1999 INWOOD / S. QUORUM - PROPERTY ACQUISITION

January 21, 1999

Re: Inwood/S. Quorum Project

EXHIBIT "A"

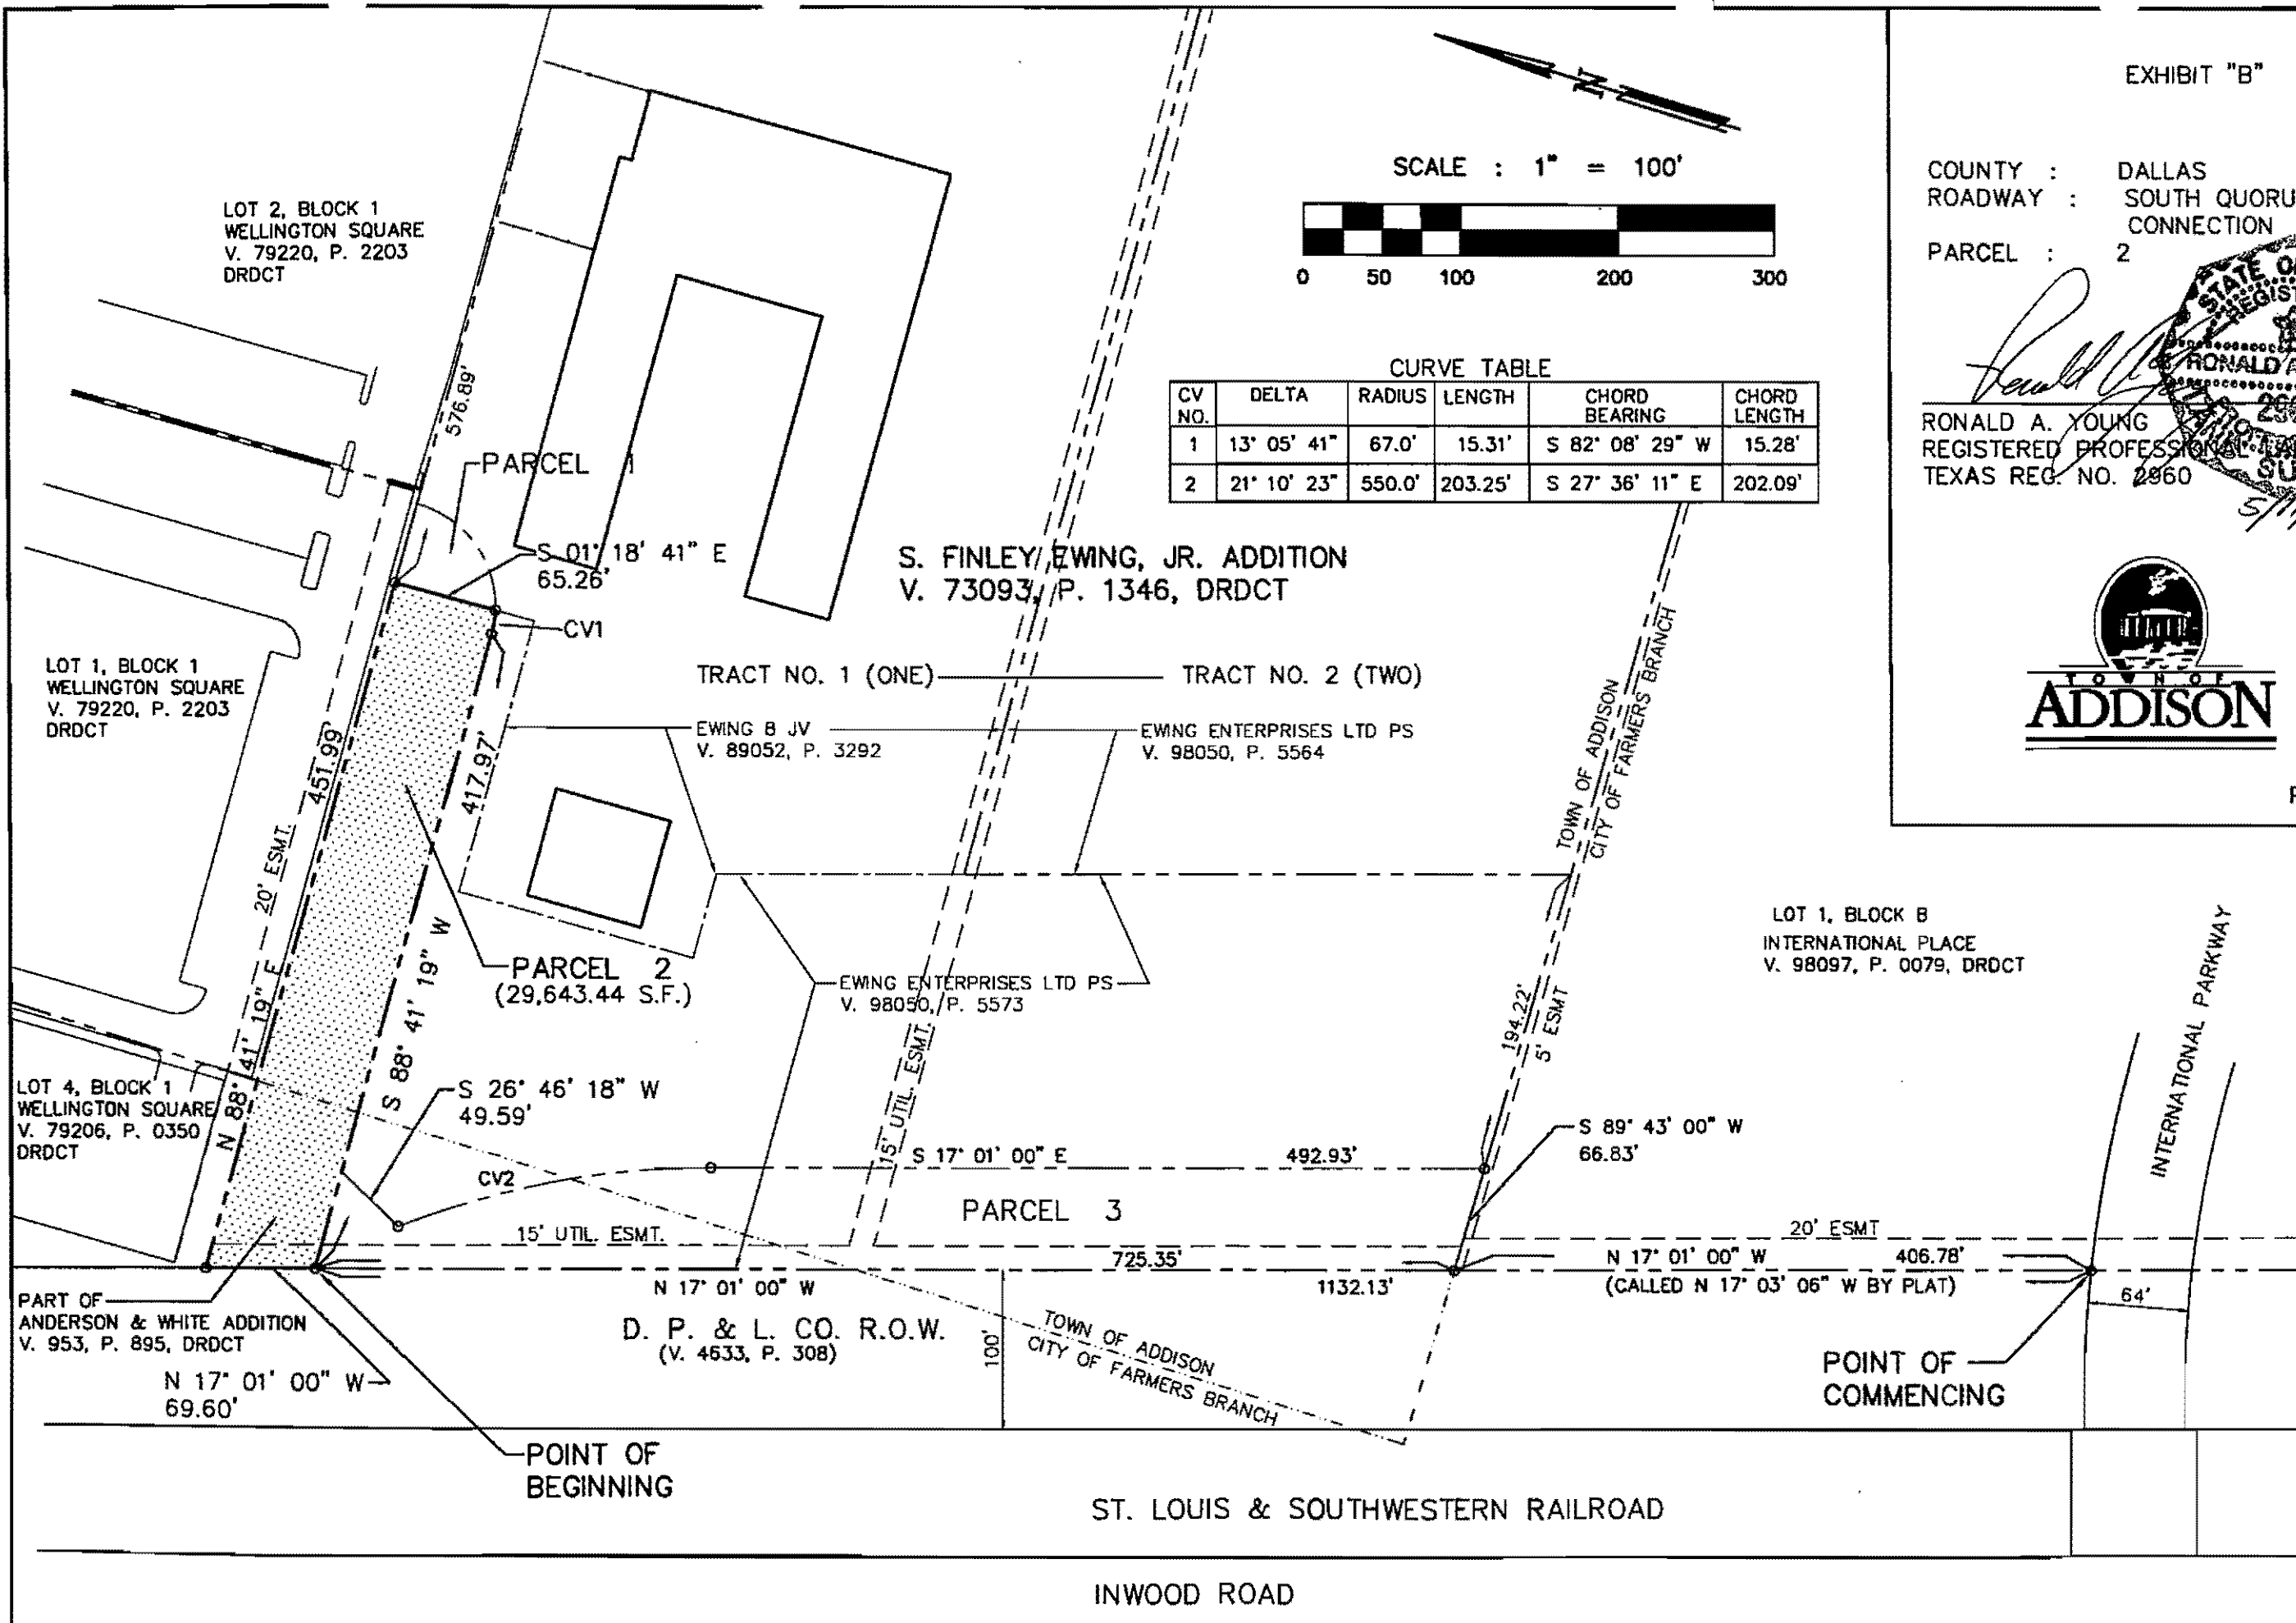
- The width of the East-West portion of Parcel 2 will be reduced by 3 feet. This will also affect Parcel 1. Parsons Transportation Group is preparing revised metes and bounds.

Comments: We met with owner & lease holder  
and based on the "paint layout", we  
agreed to take 3' off the width of  
the parkway to give more clearance  
between the corner of the garage and the  
ROW line. This would give 22' between  
the two. However, based on the attached  
CAD drawing, the road looks a little  
mis-aligned. Please review. We need to  
work this out and I ~~was~~ need new metes  
& bounds & maps to reflect the changes.  
Please call and lets discuss.
